City of Portland, Maine - Building or Use Permit Application
 389 Congress Street, 04101 Tel: (207) 874-8703, Fax: (207) 874-8716

Permit No: 05-1805	Issue Date:	CBL: 298 B041001
------------------------------	--------------------	----------------------------

Past Use: Single Family	Proposed Use: Single Family change of use for home occupation / Imported goods	Permit Fee: \$30.00	Cost of Work: \$225.00	CEO District: 5
Proposed Project Description: Change of use for home occupation / Import goods		FIRE DEPT: <input type="checkbox"/> Approved <input type="checkbox"/> Denied	INSPECTION: Use Group: Type	
		Signature:	Signature:	
PEDESTRIAN ACTIVITIES DISTRICT (P.A.D.)				
Action: <input type="checkbox"/> Approved <input type="checkbox"/> Approved w/Condition <input type="checkbox"/> Denied				
		Signature:	Date:

FLOOR PLAN

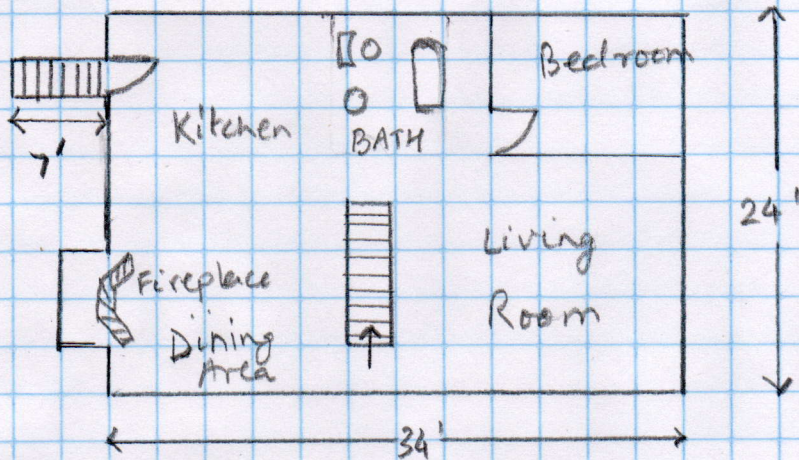
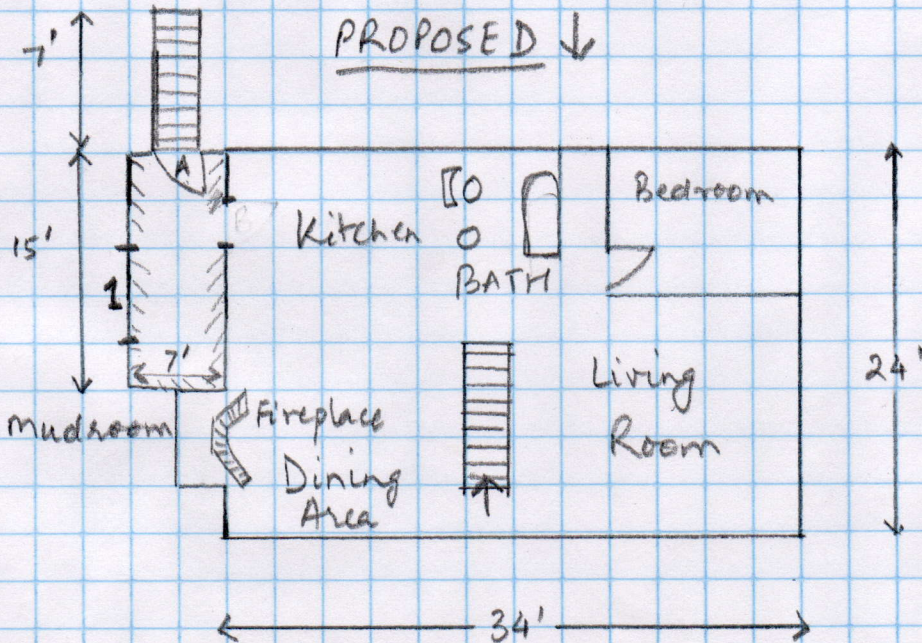
12/16/05-amachado: I left a message with InduBala Gupta. She needs to give us more complete dimensions of the home occupation area and more detail about exactly how that space will be used.
